**Canal &
River Trust**

Proposal: EN0110001 Keadby Next Generation Power Station Project.

Canal & River Trust Response Submission for the Pre-examination procedural deadline

Indicative Workboat Location - Keadby  
& Stainforth Canal

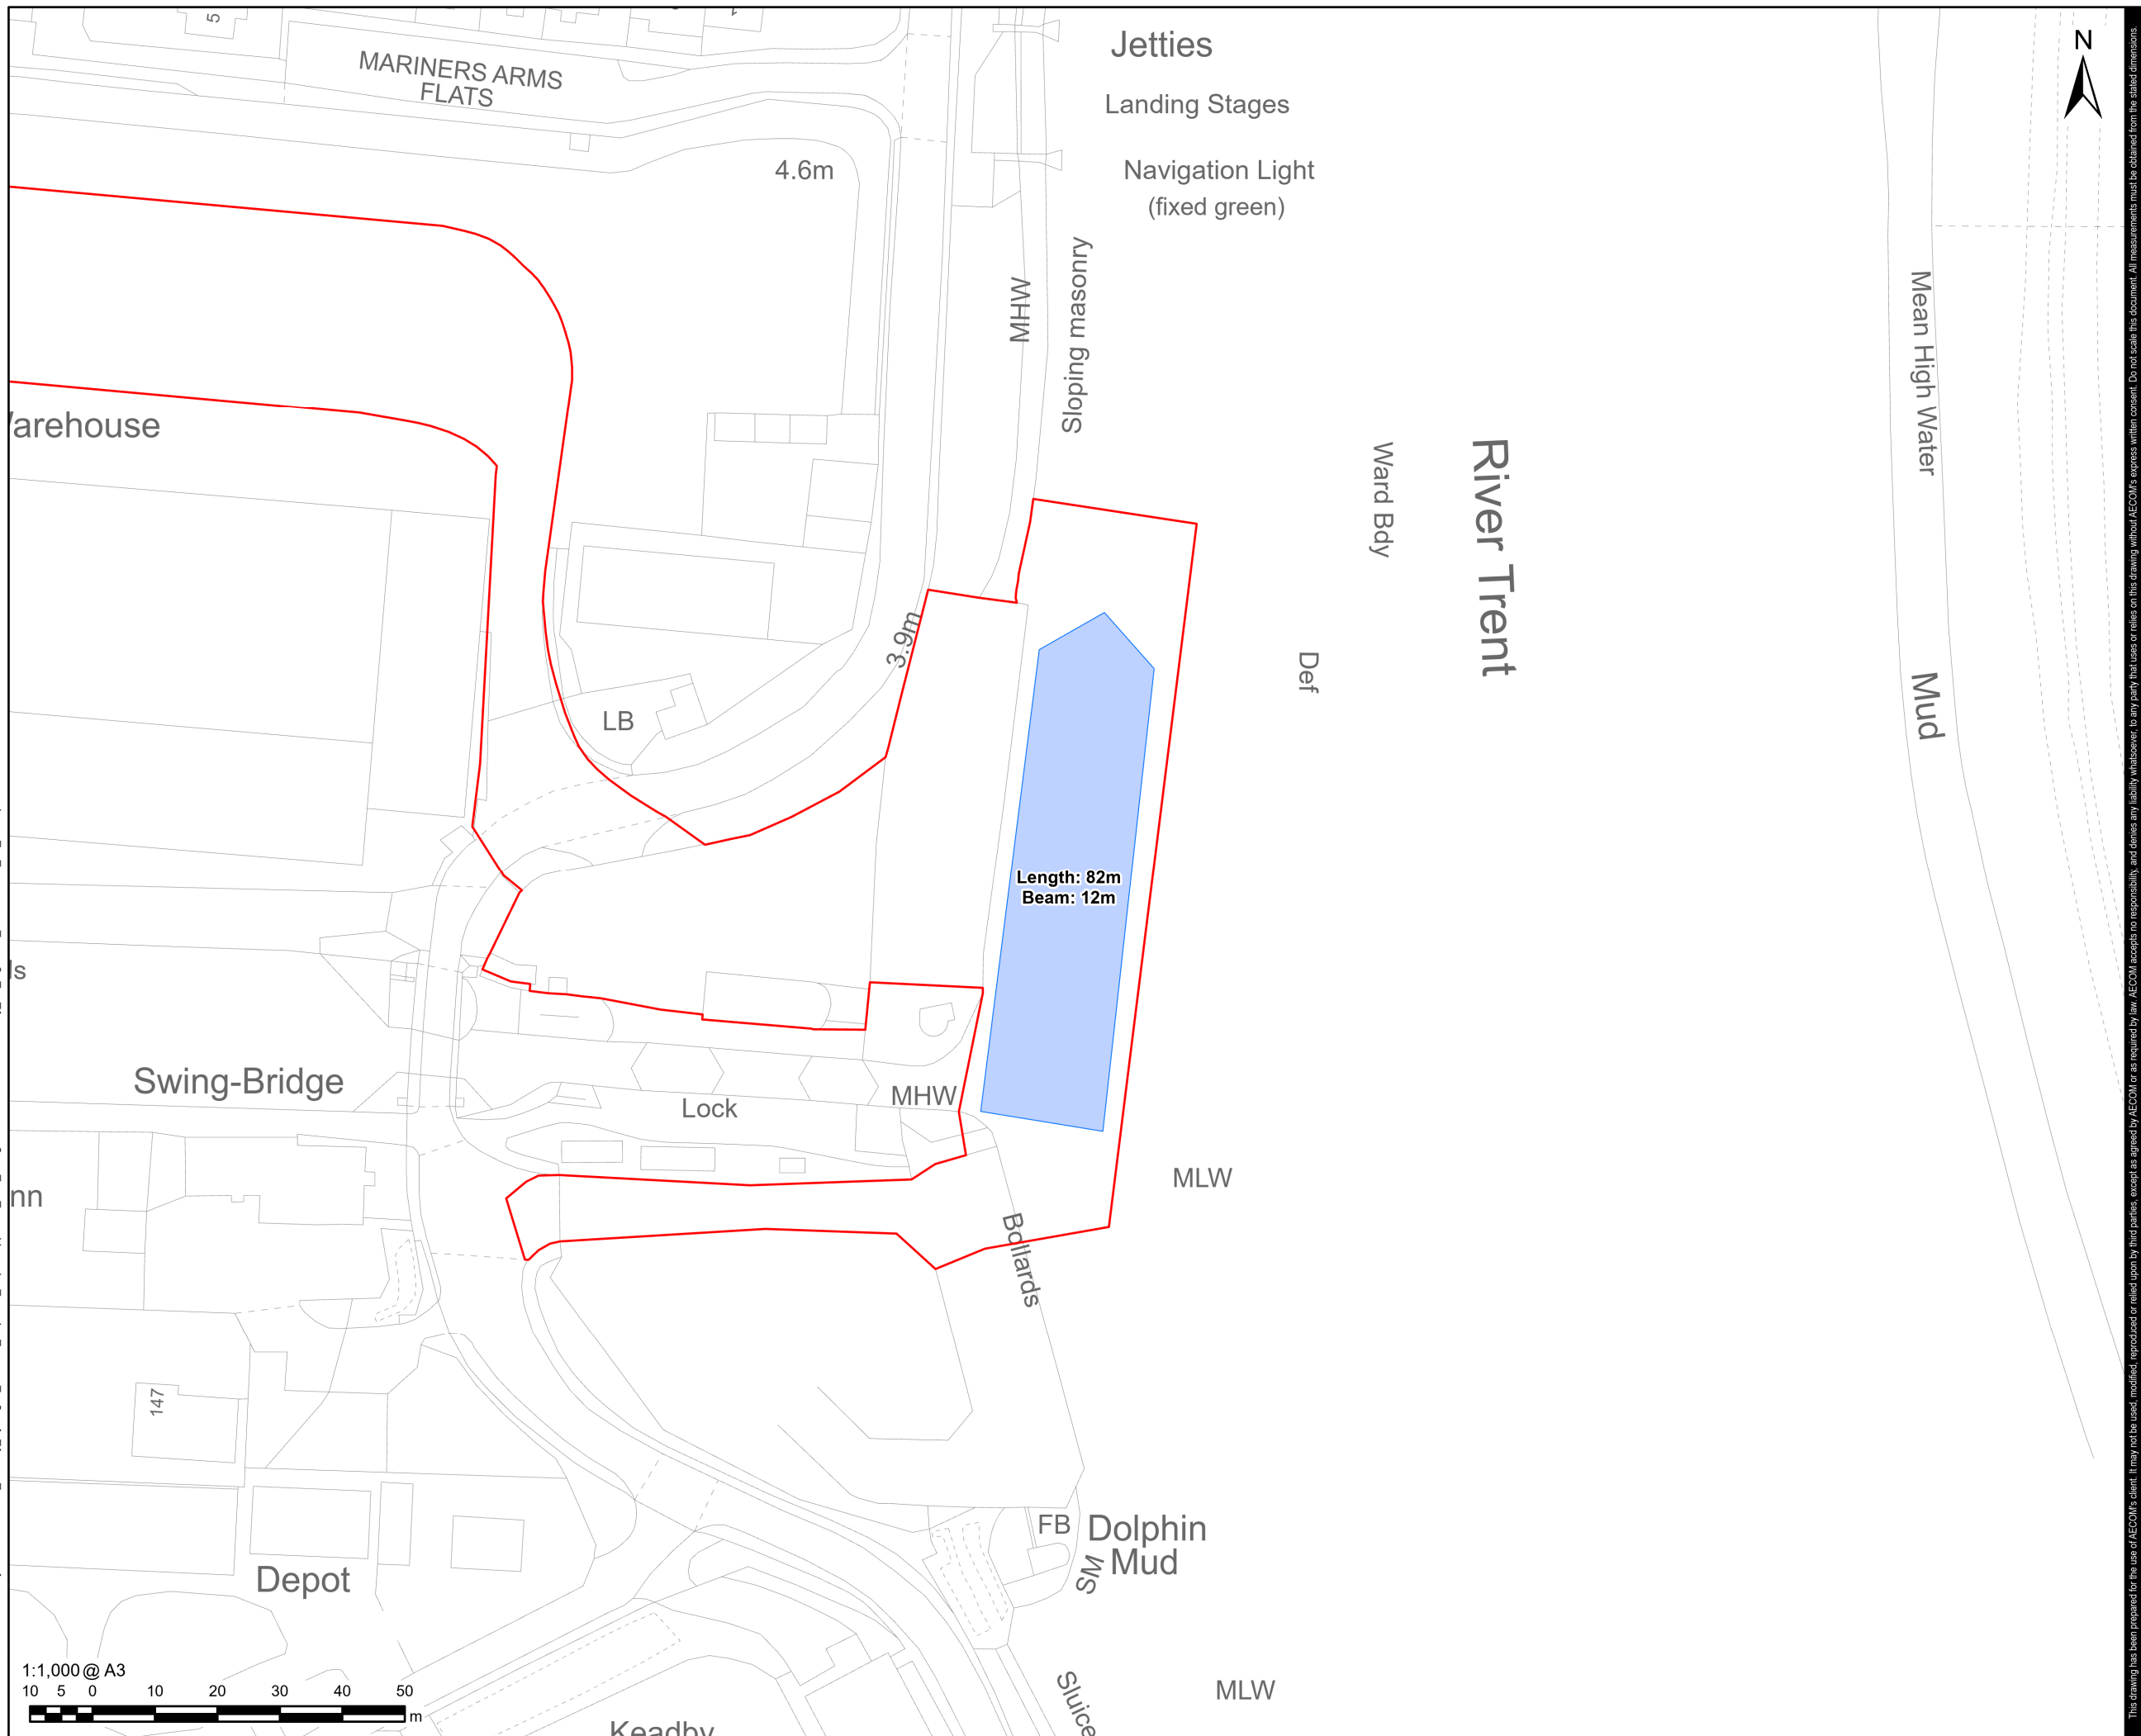
The proposals would temporarily restrict the navigable width of the Canal by 20m. This would have the effect of closing the canal to traffic. We request that the total restriction in navigable width should be limited to 10m. Cofferdams with of up to 10m were used during the construction of the Keadby 2 project.
